Date 27 March 2023

RE: 6/2022/2220/COND – Stadium Service Station, Stanborough Road, Welwyn Garden City AL8 6XA

We understand the applicant has submitted the above application as re-consultation for discharging conditions 1,2 and 17 which are either linked directly or indirectly to flood risk, surface water management and drainage.

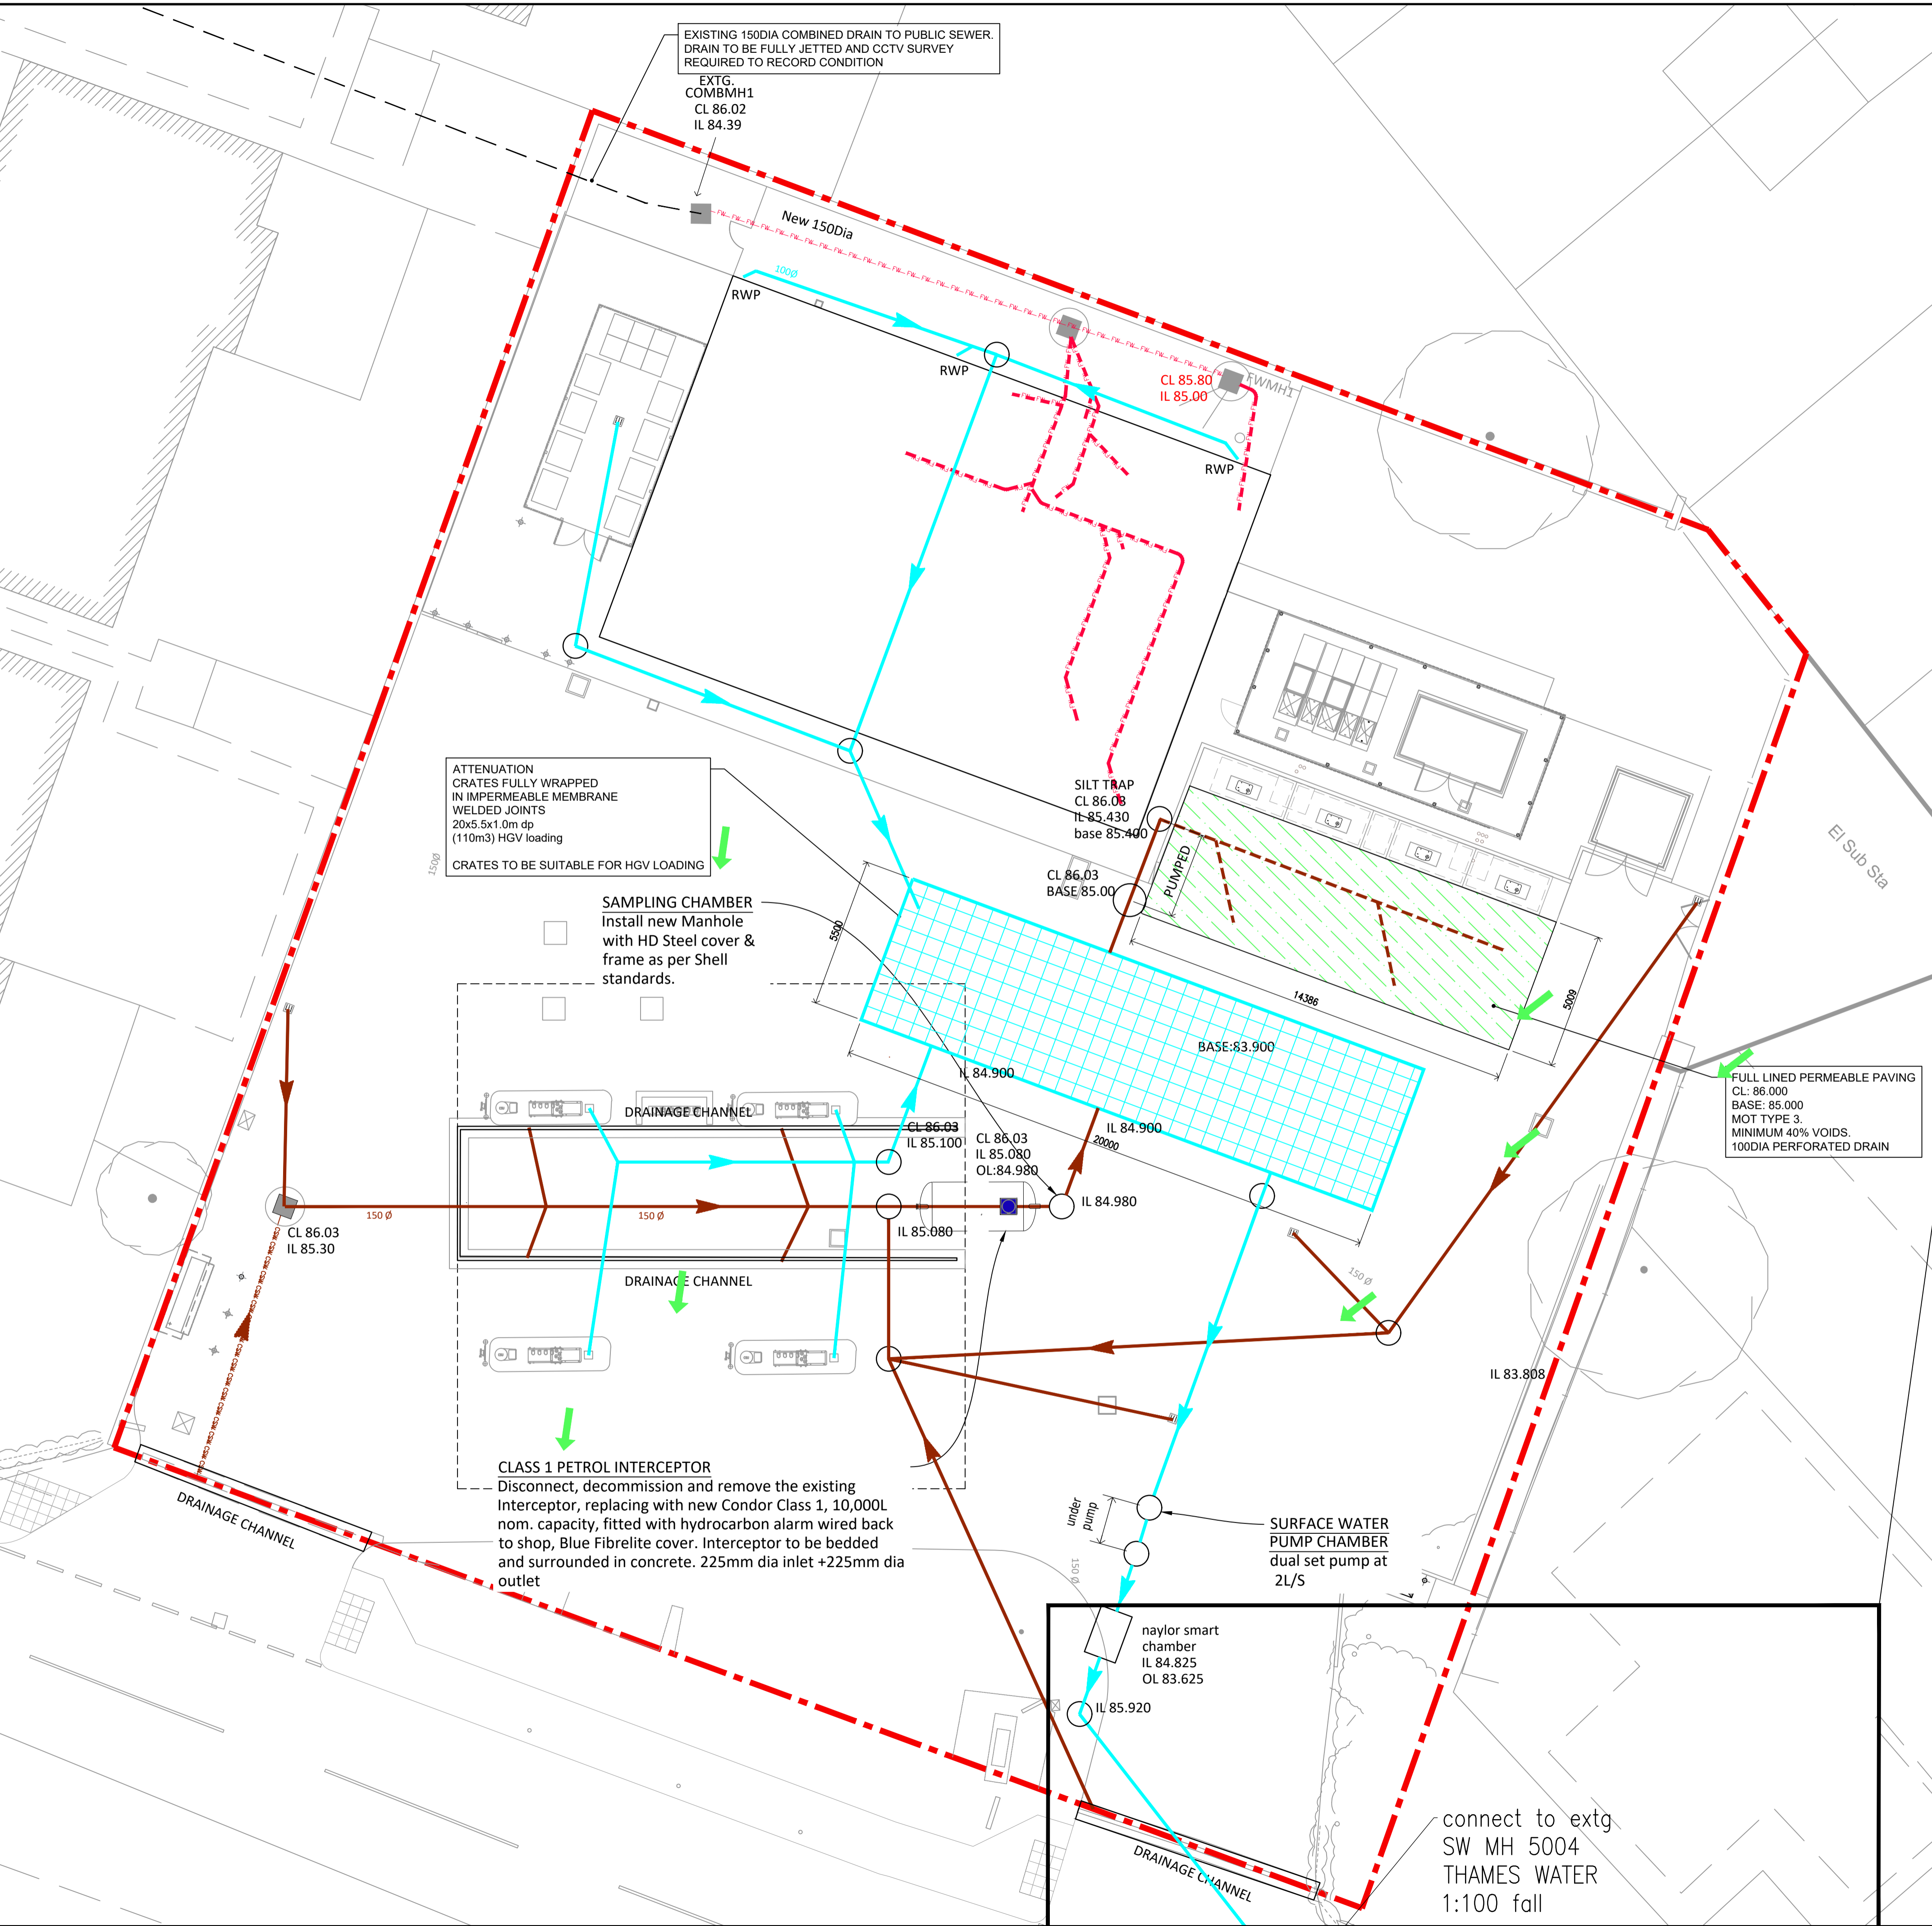
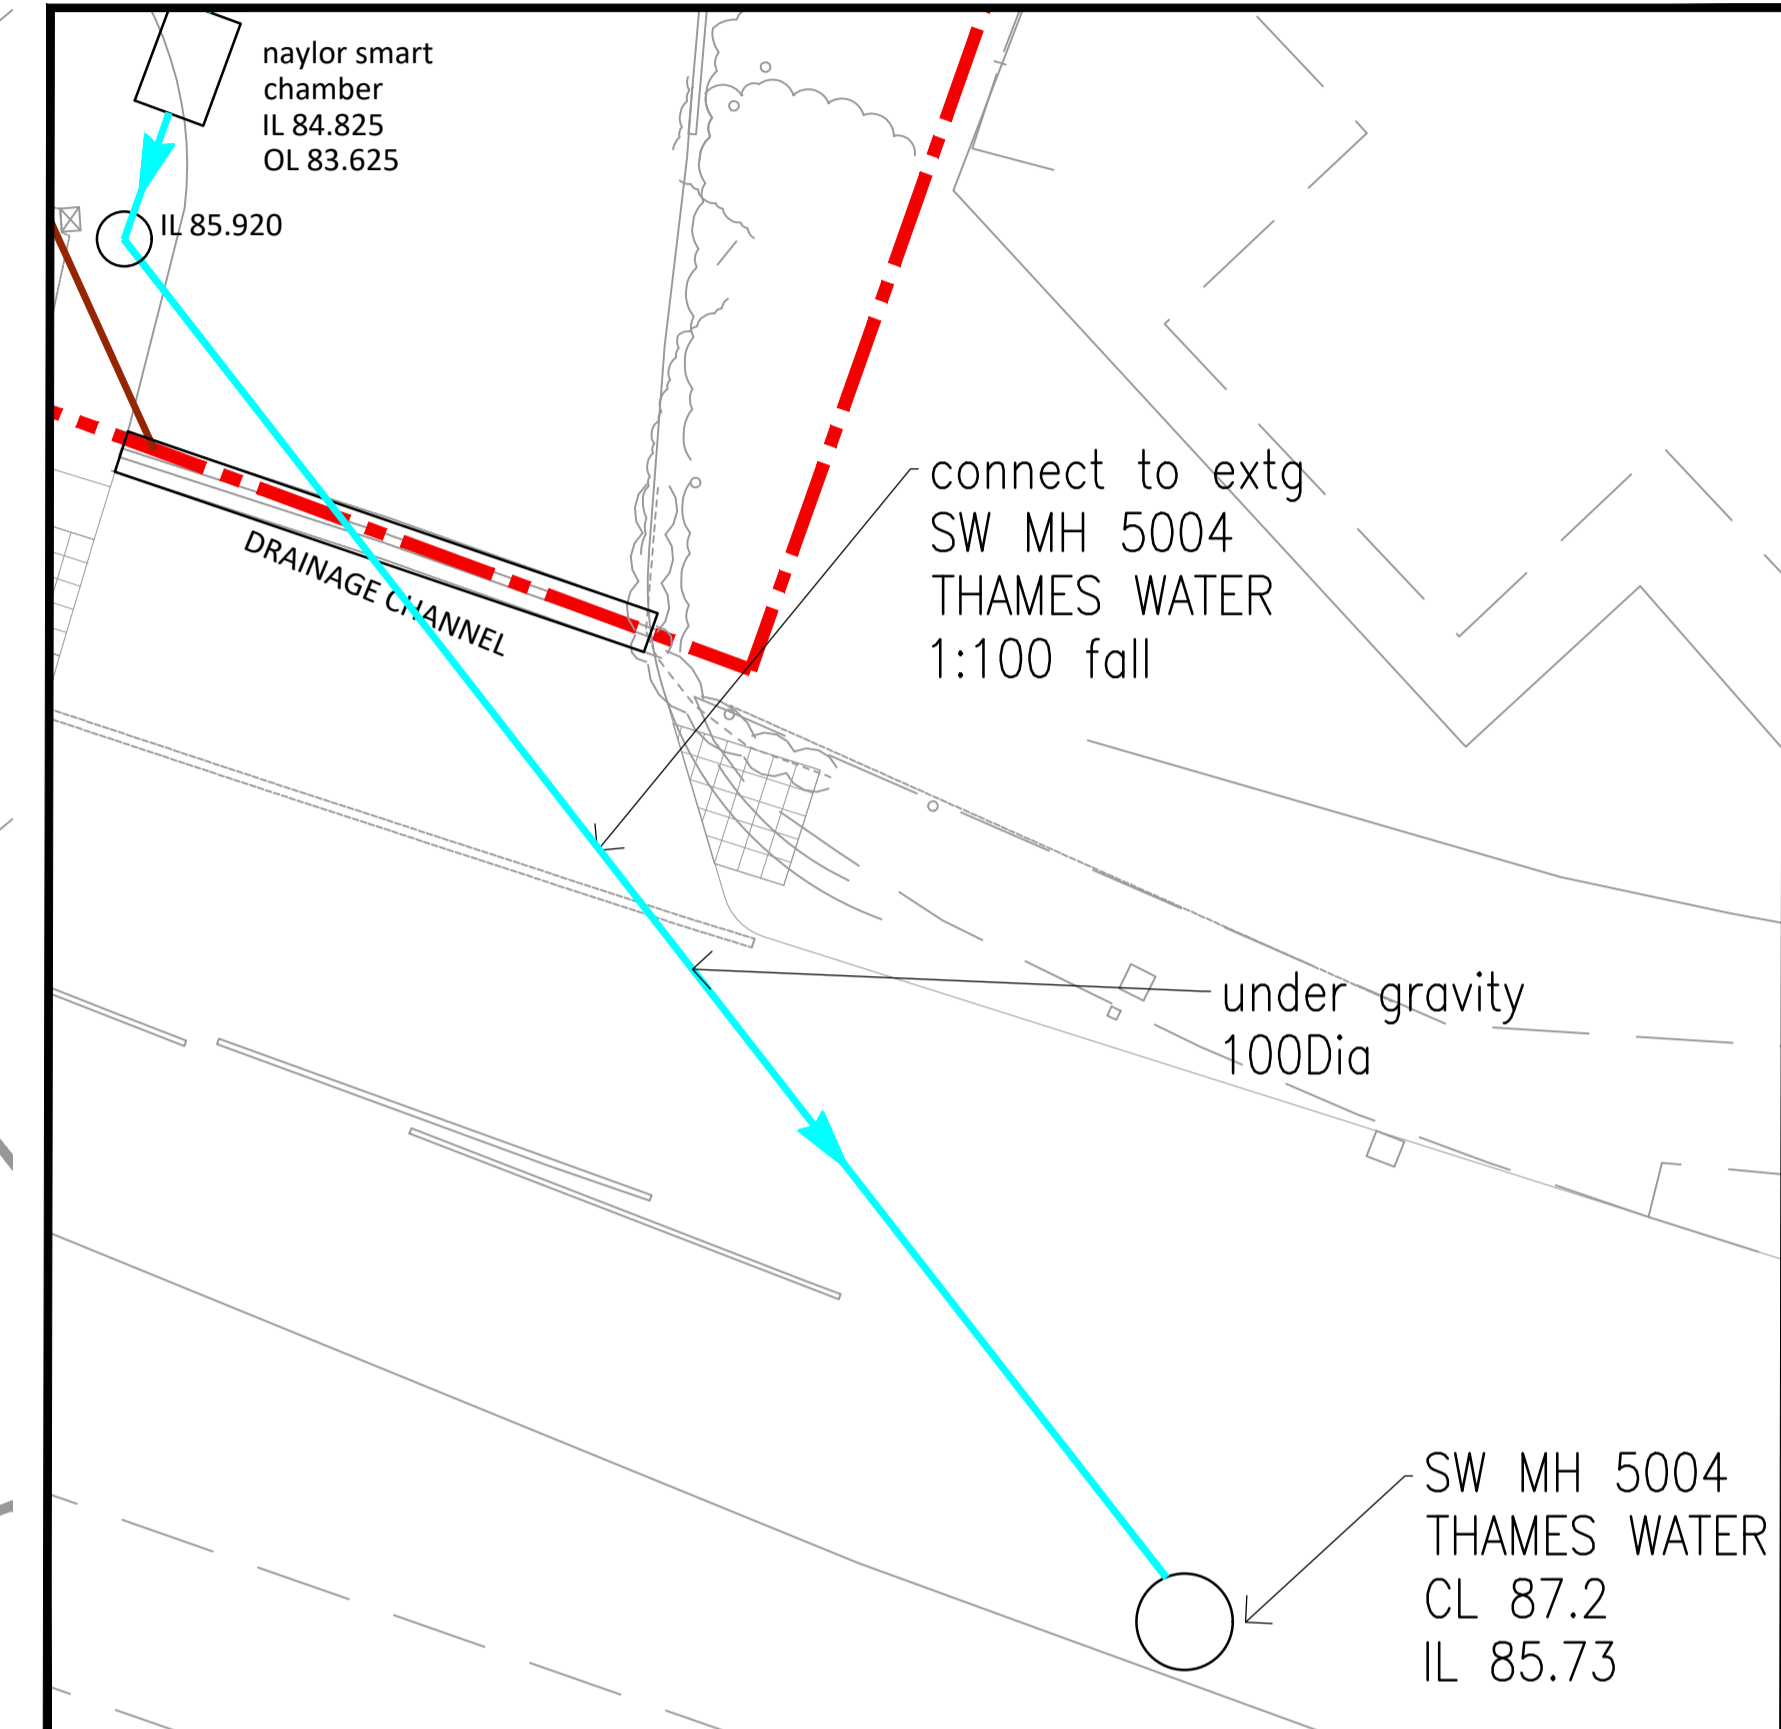
There also needs to be a clear representation of the exceedance routes with the key/legend on the drainage plan within Appendix D. **Therefore, the LLFA consider this objection point remains unresolved.**
